## RE: 31 Fore St- submissions to meet conditions

Hi Jean – I have reviewed the revised plans as it relates to conditions of approval and I find the plans to be acceptable with the following comment.

### 3. Construction Management Plan

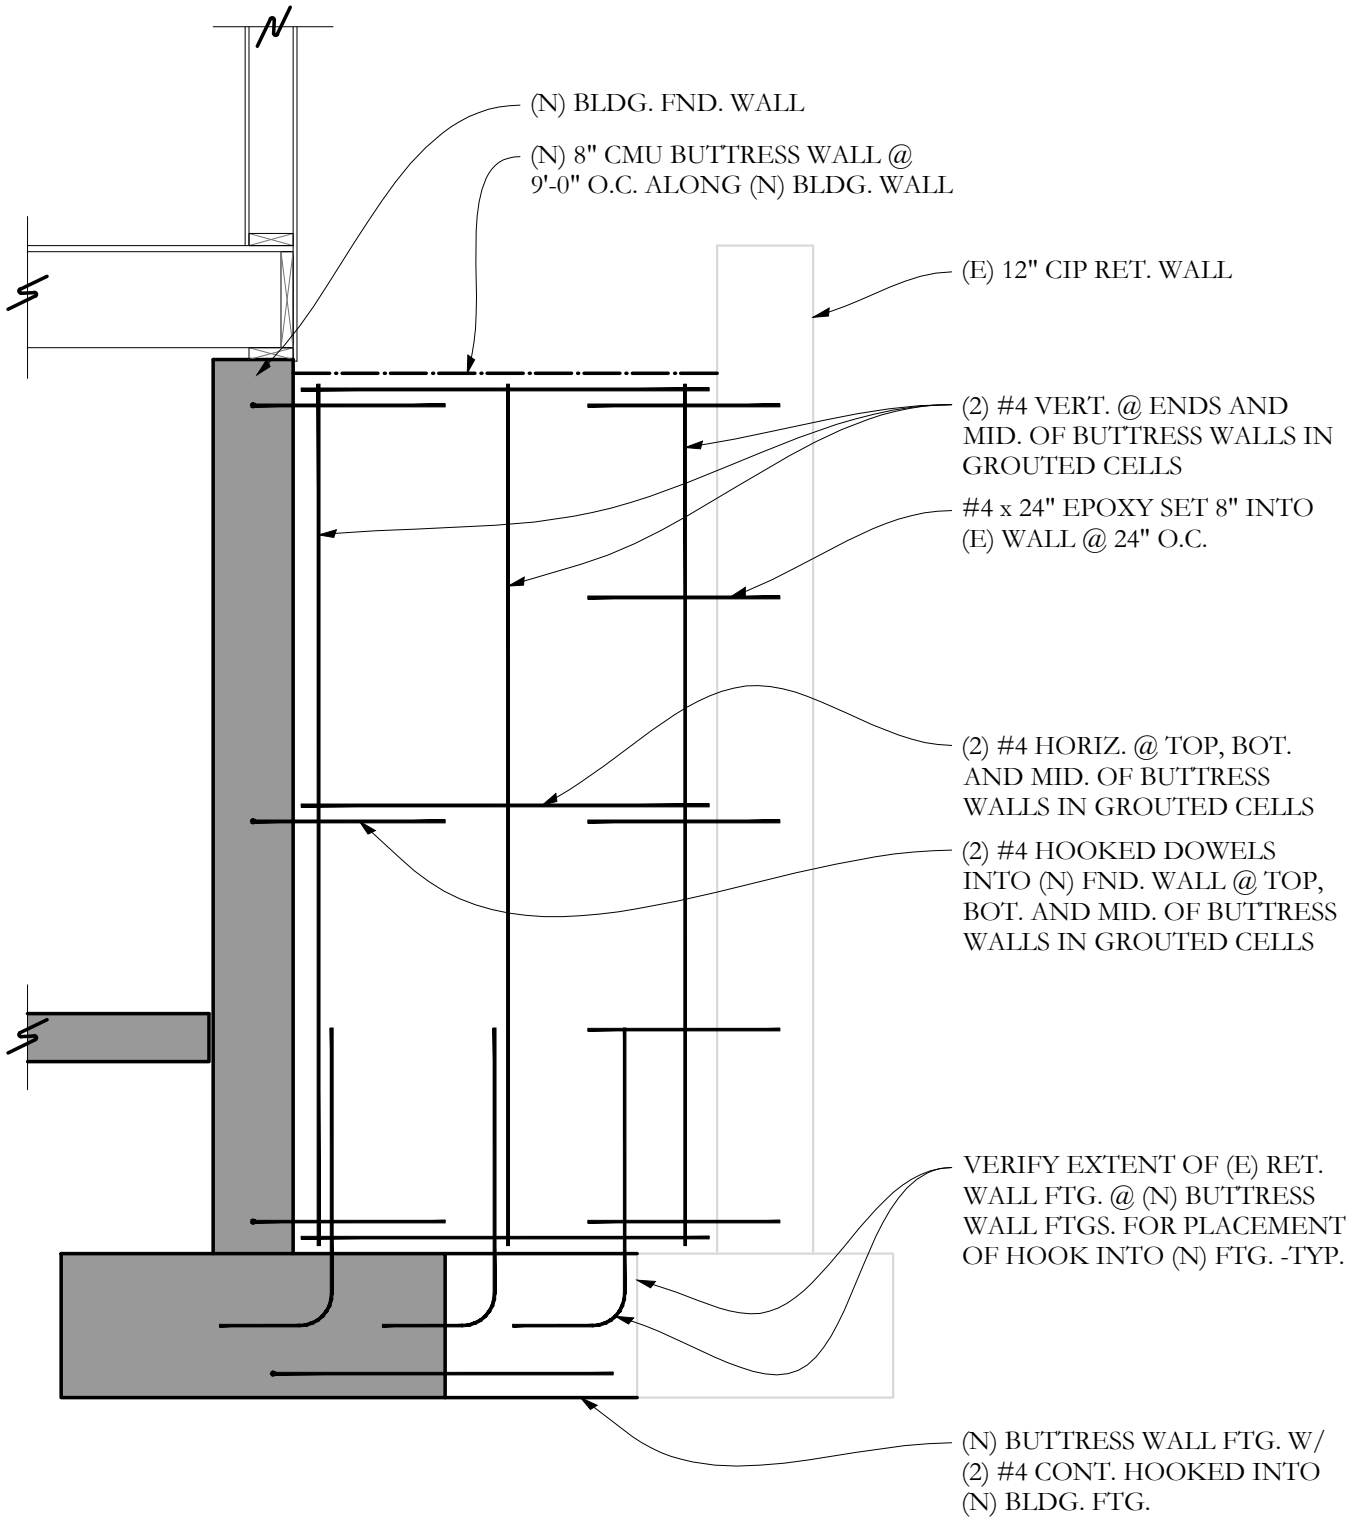
- The applicant has provided a general construction management plan. I would note that the plan shall maintain either the existing sidewalk or a temporary sidewalk along Fore Street (without detouring pedestrians to the opposite side) during construction. A sidewalk detour will be permitted on Waterville Street and is subject to review of final details. The applicant shall provide a final plan details and proposed contractor parking specifics, for review and approval, prior to the pre-construction meeting.
